AW/26/21/L

149 Barrack Lane Aldwick PO21 4ED

Listed building consent for replacement conservatory to rear of property

DRAWING TITLE
REPLACEMENT CONSERVATORY
PROPOSED PLANS & ELEVATIONS

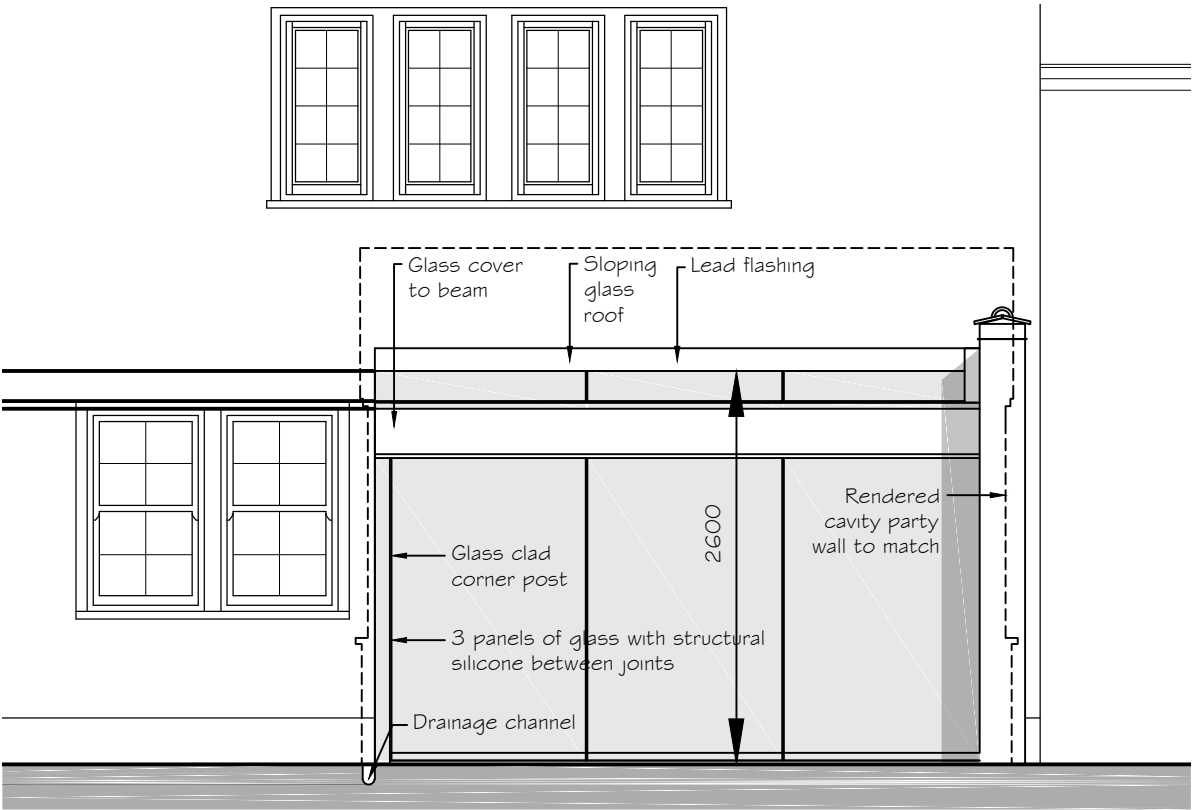
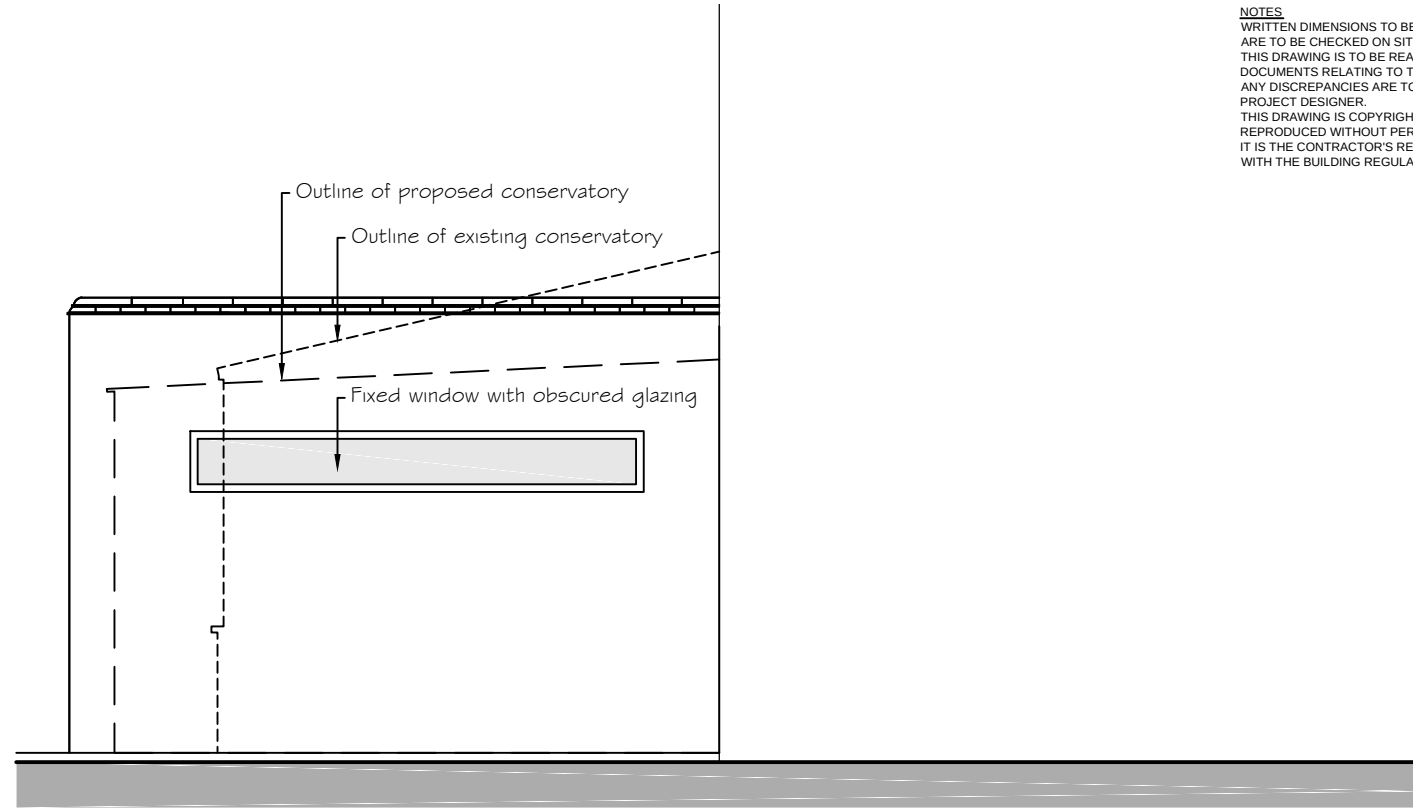
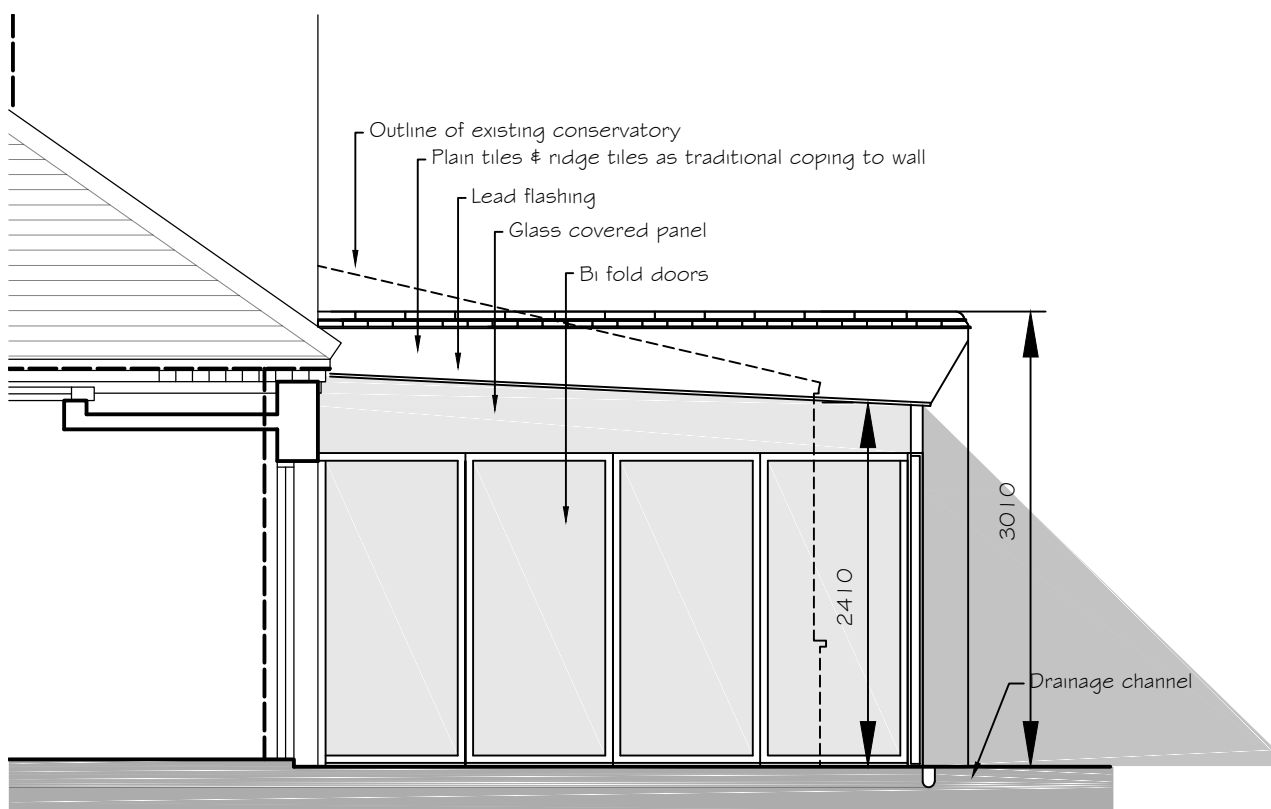
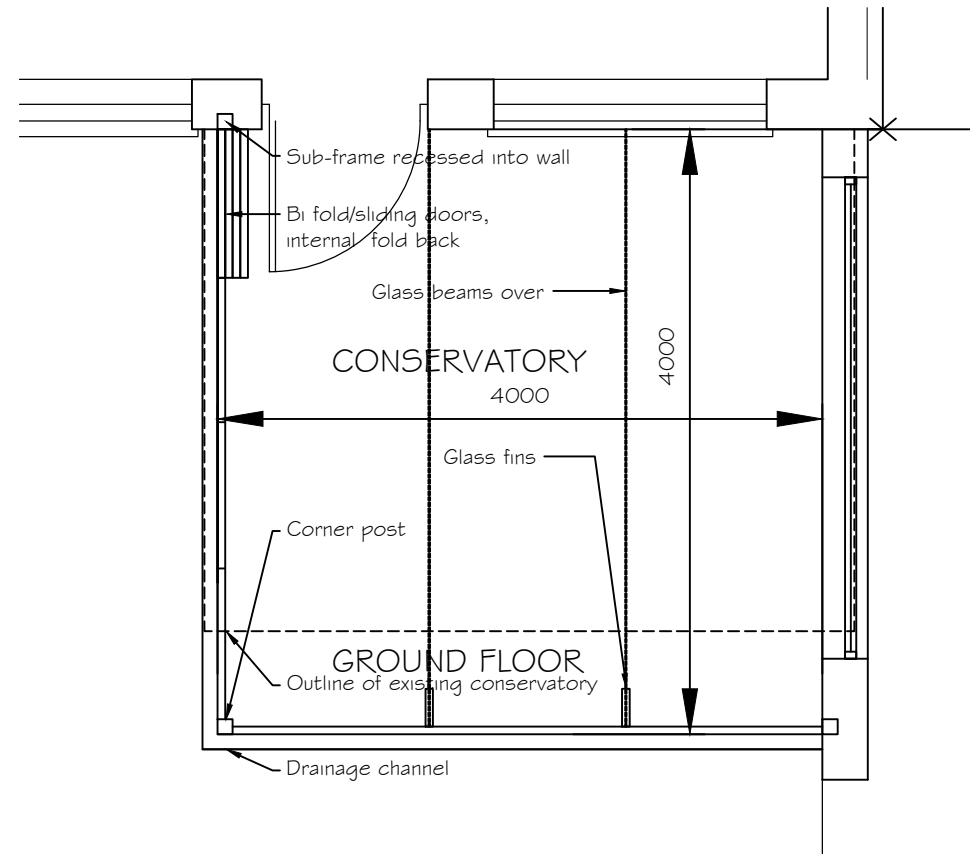
The replacement conservatory is simpler and more modern in appearance than the existing structure and includes larger areas of glazing. The plans indicate that the intention is for the glazing to be frameless, with the southern elevation consisting of three panels with structural silicone joints. It would therefore be a more lightweight structure which would allow more of the rear wall of the house to be visible. This approach is acceptable in the context of a building which has continued to evolve and change, especially in the mid C20 when it was converted into two homes and substantial alterations were undertaken.

If minded to approve the application, it would help to view the details of the bi-fold doors. This could be achieved by way of condition.
